Our ref: DOC21/17584-9
Your ref: SSD 8660

**State Significant Development SSD 8660 – Construct and operate resource recovery facility
– 90 Gindurra Road, Somersby**

I refer to your email dated 14 January 2021 requesting comment from the Environment Protection Authority (**EPA**) about SSD 8660 (**the Application**). The Application seeks to construct and operate a resource recovery facility to process 200,000 tonnes per annum of soils and building and demolition waste at 90 Gindurra Road, Somersby.

SHEET NAME TIP AND SPREAD BAYS - PLAN AND SECTION

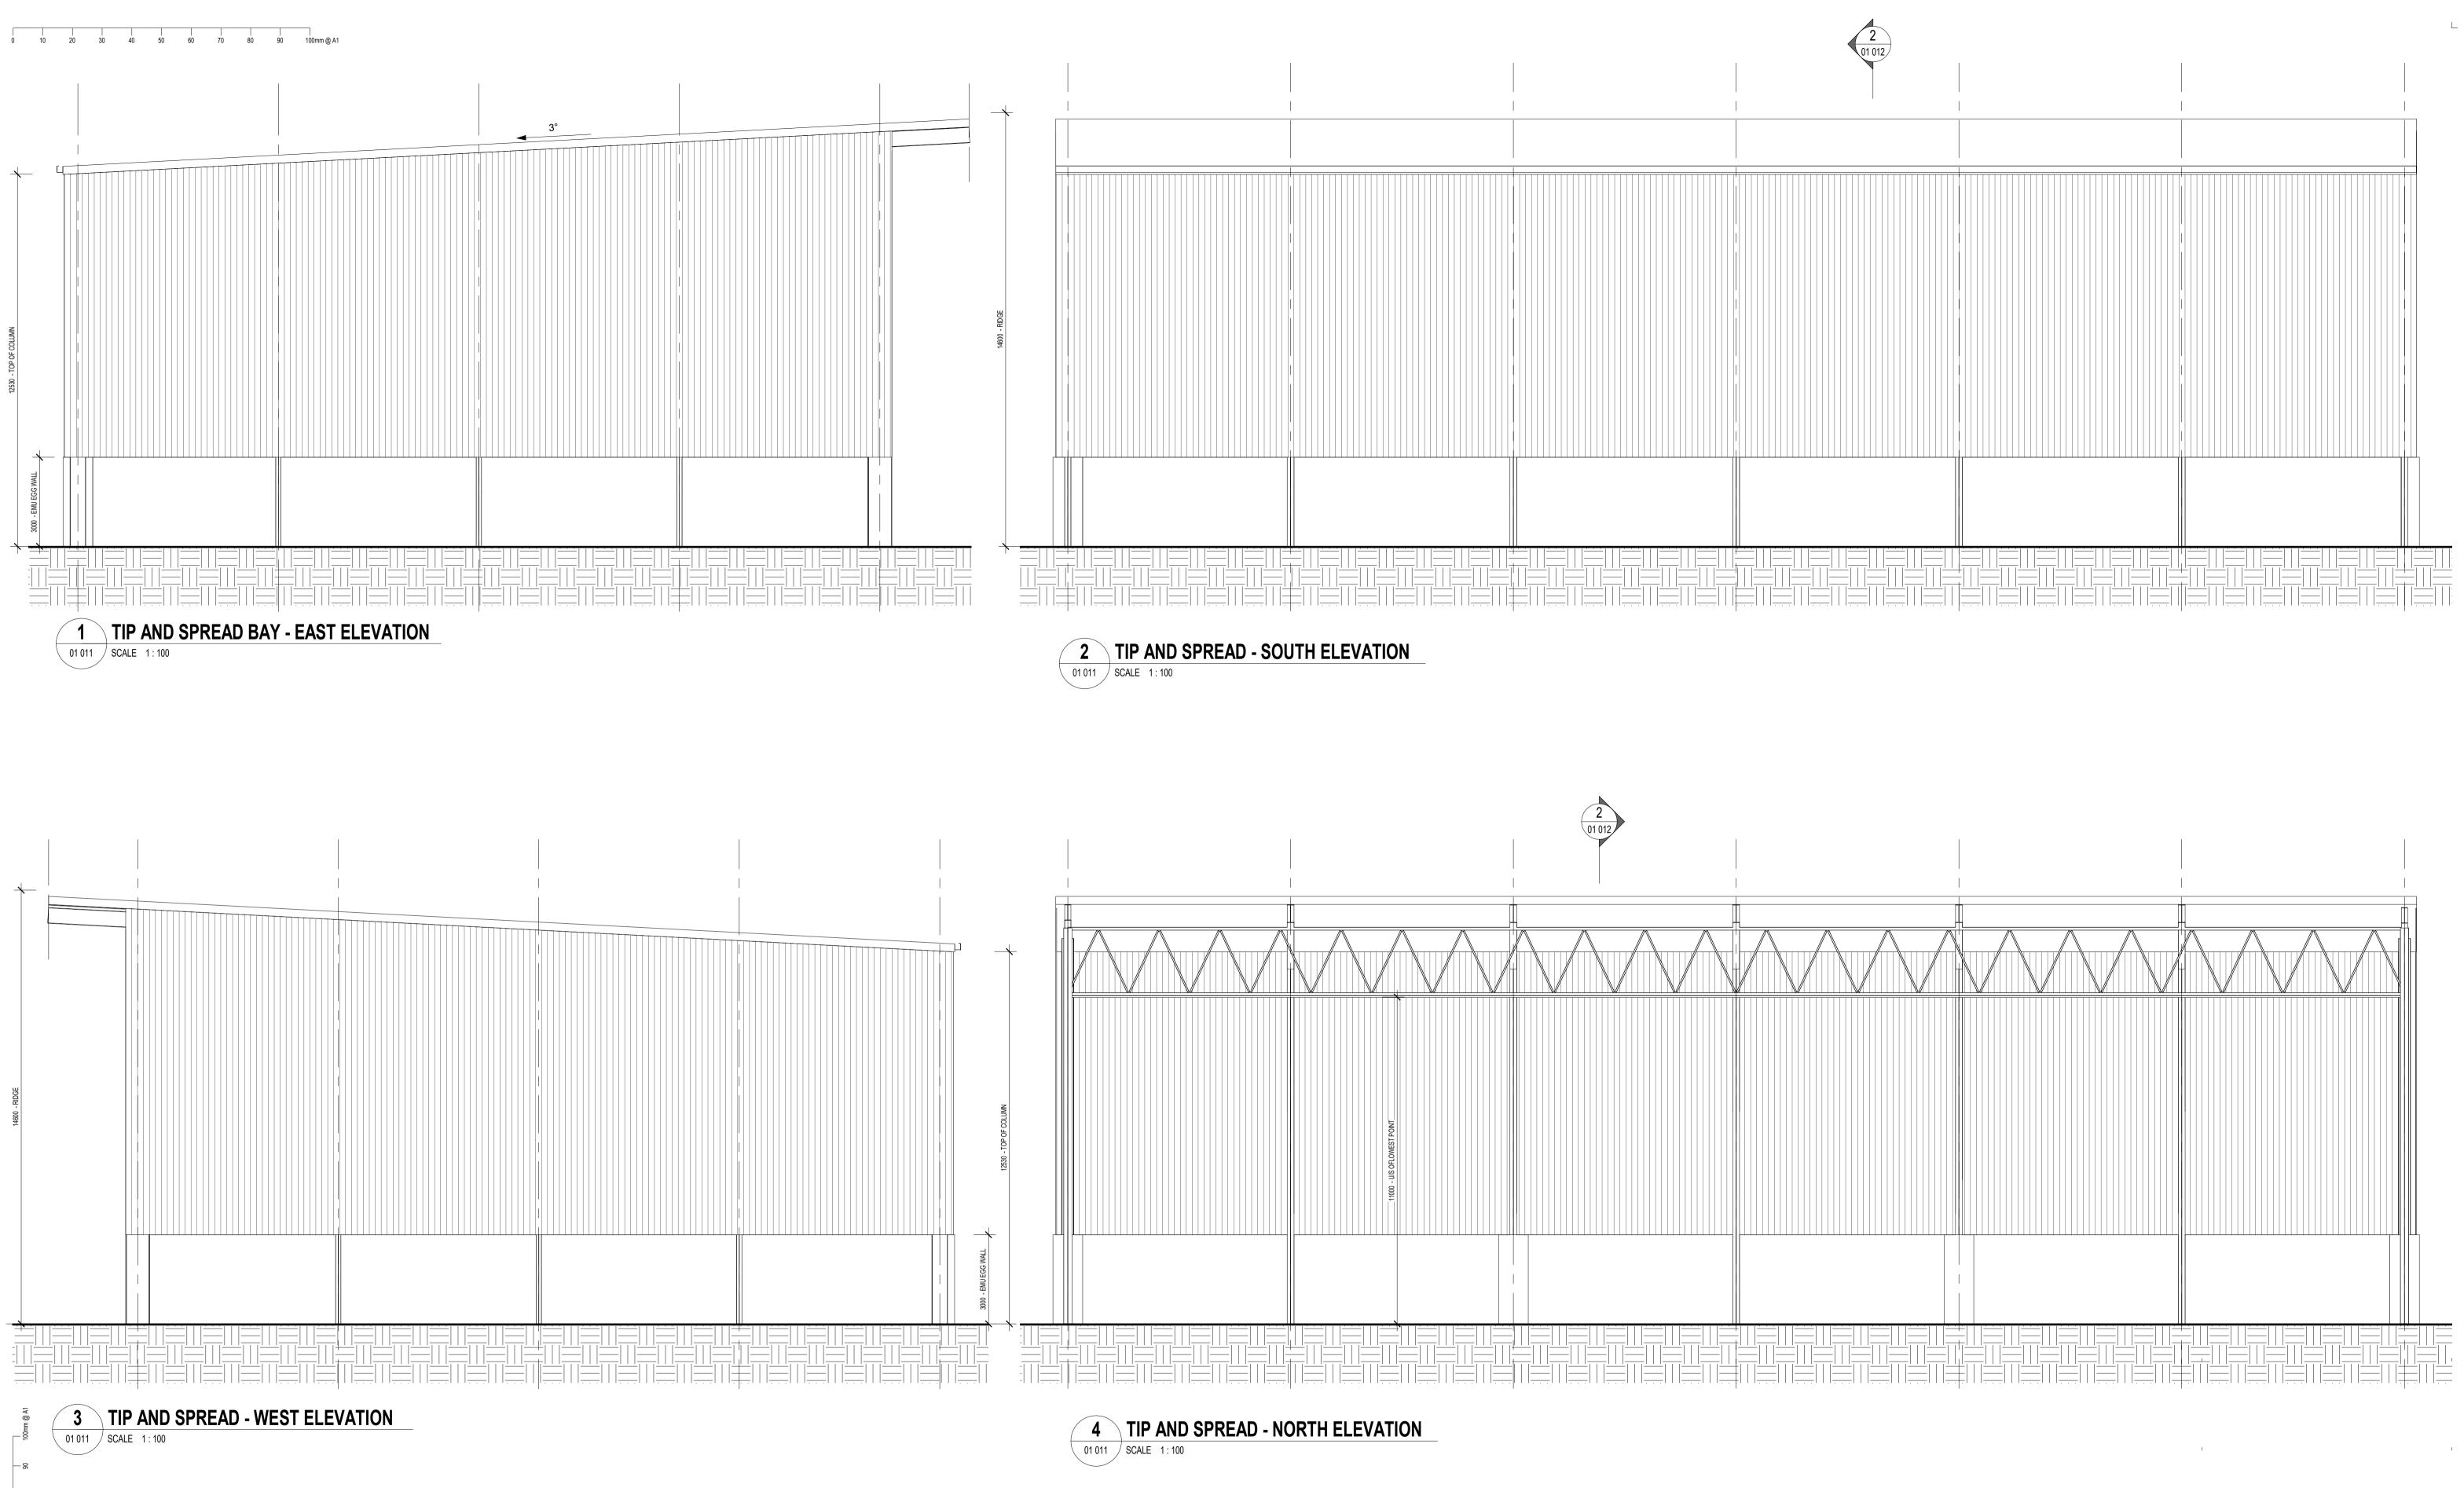
It is proposed that the tip and spread building will only have three fully enclosed sides, with a large open front for vehicle access. The EPA considers the design of the structure could be further improved by fully enclosing all sides of the building. However, the risk of air quality impacts occurring from this building have been reduced via a ceiling mounted dust suppression system. Additional management measures such as minimising drop heights, visual monitoring and hand-held dust suppression are also proposed. As such, the EPA considers the risk of potential air quality impacts from the building are low, where site operations are managed appropriately.
